DOC21/805693-4

Shoalhaven Starches – Mod 21 – Modification to Approved Packing Plant – EPA Comments

Thank you for the request for advice, requesting the review by the NSW Environment Protection Authority (EPA) of the Statement of Environmental Effects (SEE) for the proposed Modification to the Approved Packing Plant (MP06_0228-Mod-21) at Shoalhaven Starches, located at 160 Bolong Road, Bomaderry.

Figure 7 CALMET wind rose for the factory

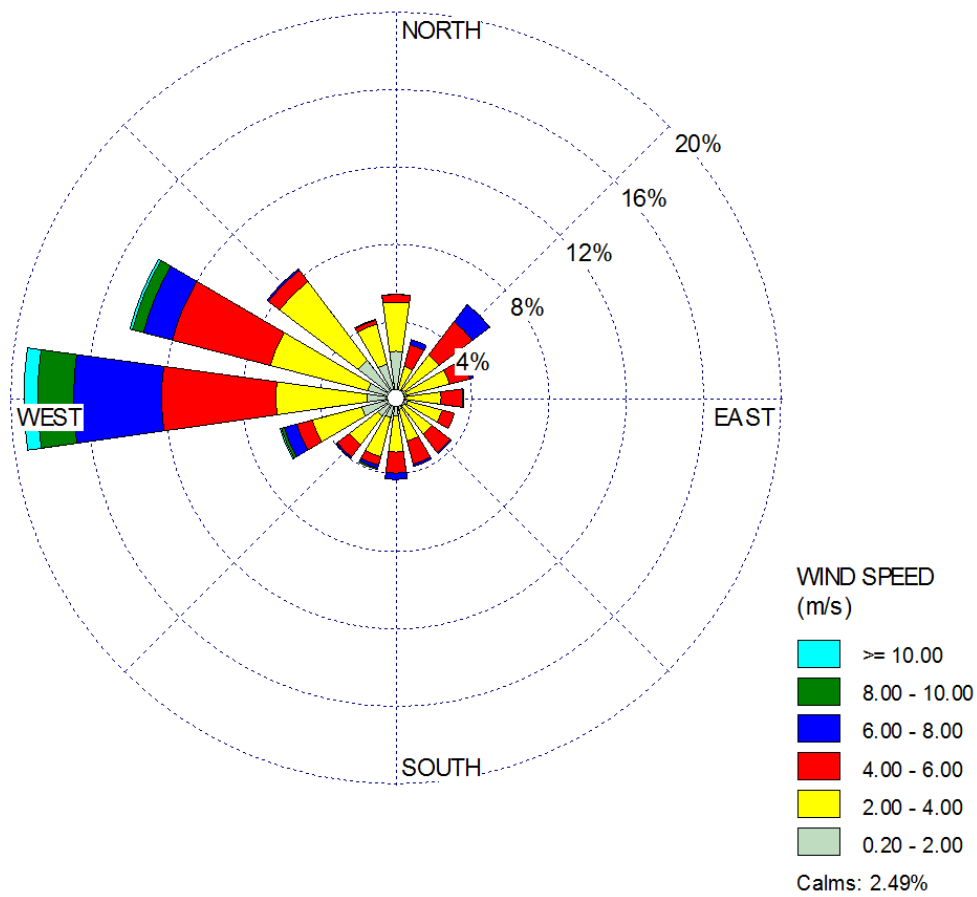
Section 5.2.1 in the AQIA includes a comparison between the CALMET generated data used in the dispersion modelling (year 2004) against on-site monitoring data (29/04/2019 - 26/05/2020). The comparison concludes that the “*General wind pattern alignment between observations and modelled*

meteorological conditions is considered acceptable” and that “the modelling data may be over predicting impacts to the south”.

However, it is noted that the comparison shows that CALMET data underpredicts low speed conditions (e.g. winds between 0.5 - 3 m/s), which are linked to poor dispersion conditions. Therefore, it is likely that the use of this meteorological data underpredicts odour impacts at the identified receptors, especially, at those near the premises.

The EPA recommends the meteorological modelling (and therefore dispersion modelling) must be revised to incorporate site-specific data.

Figure 4. One-Third Octave Band Spectrum Baghouse Motor – Reverberant Field

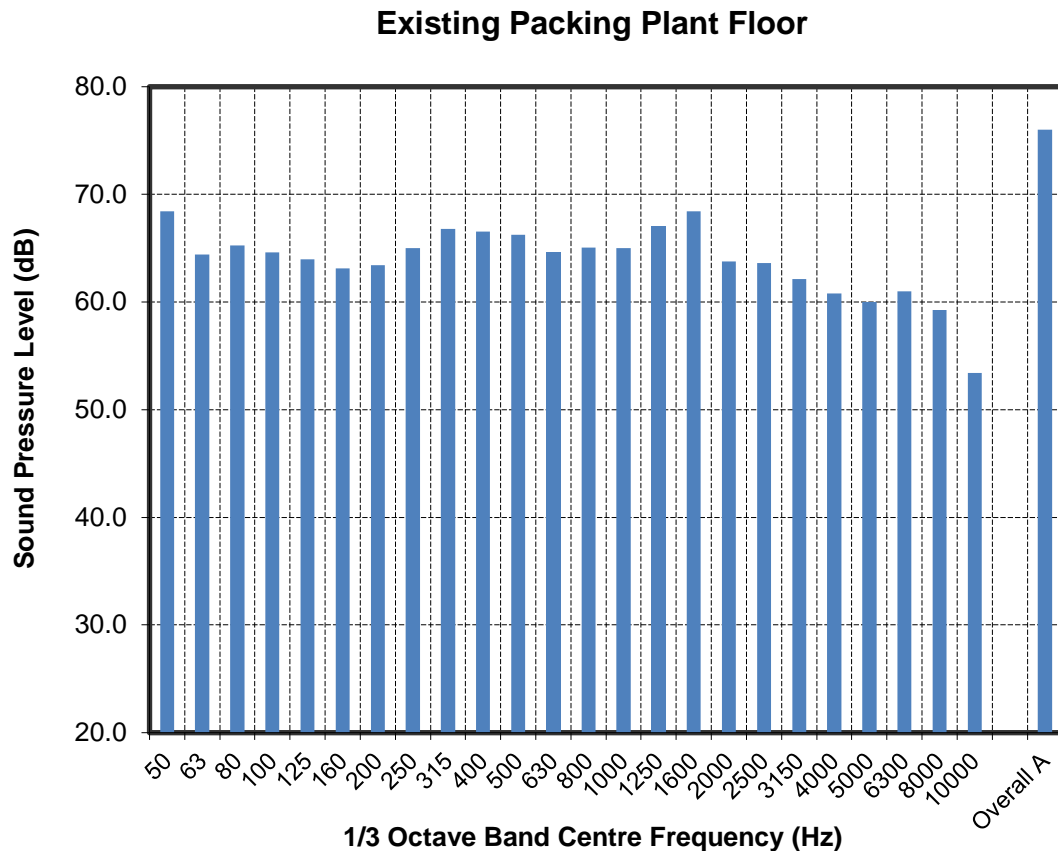
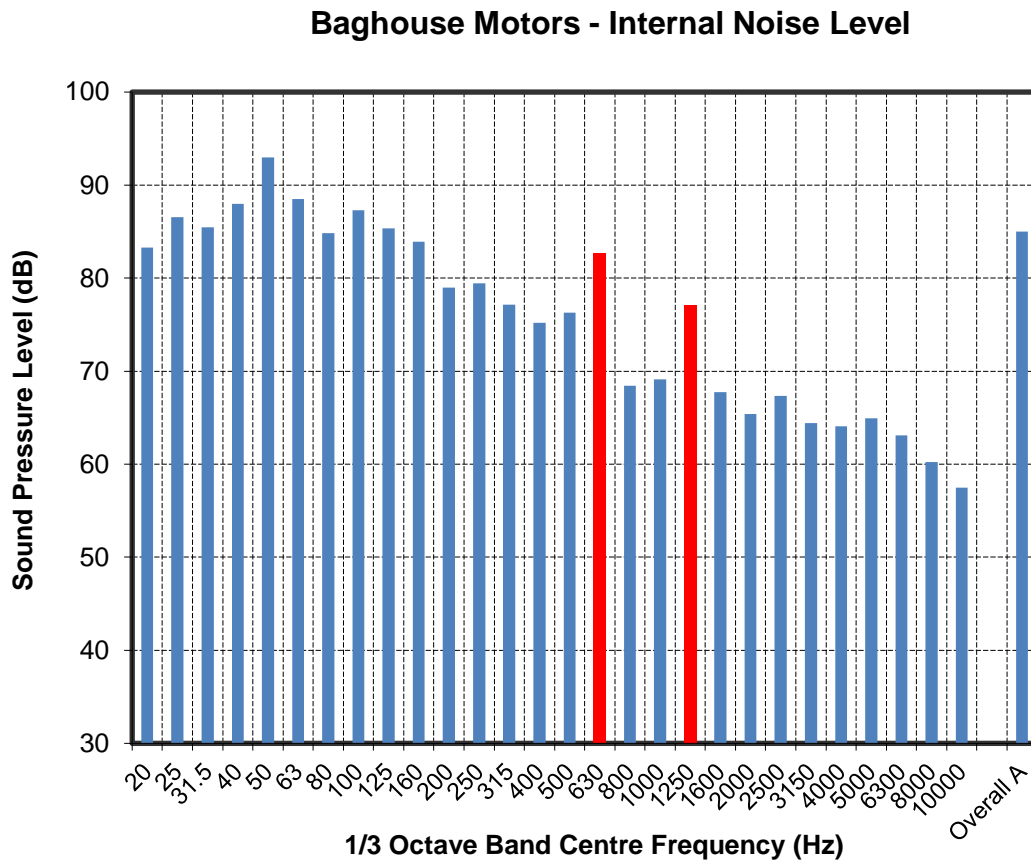
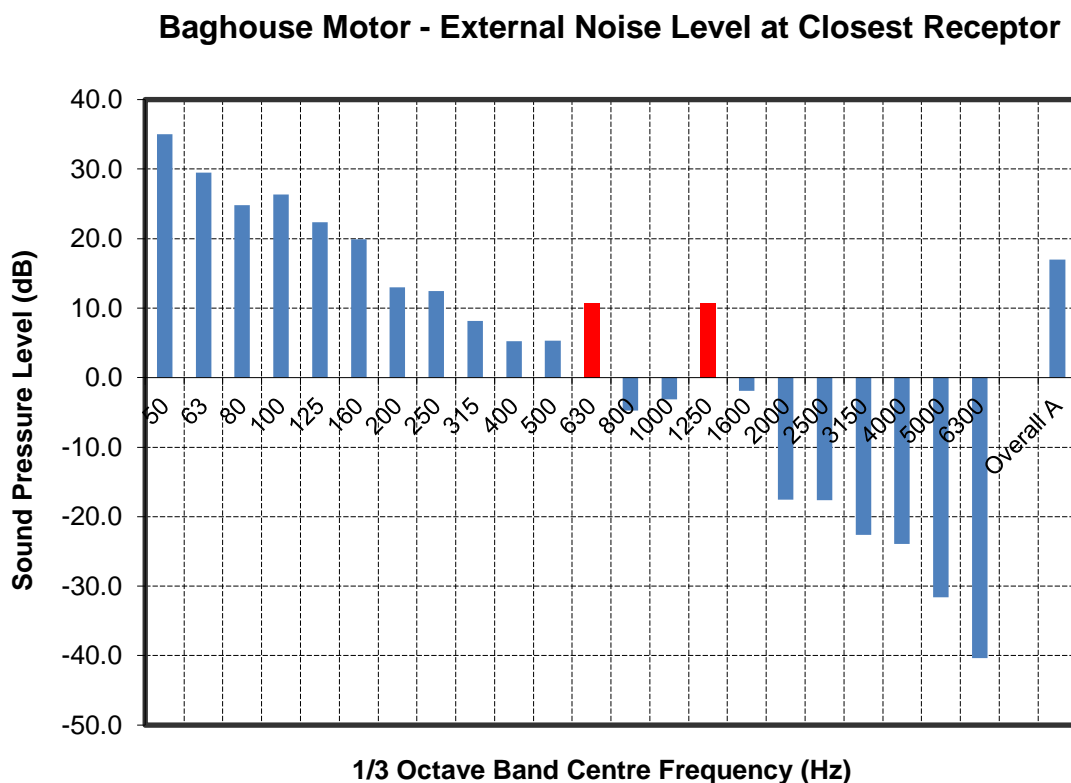
Section 4.2.3 presents the "Modifying Factor Assessment". The assessment states 'no modifying factor adjustments are applicable' however it only appears to consider tonality and low frequency noise.

The EPA also requests the proponent provide more information to support the claim that 'the noise levels are not expected to contain tonal characteristics at any receptor location'.
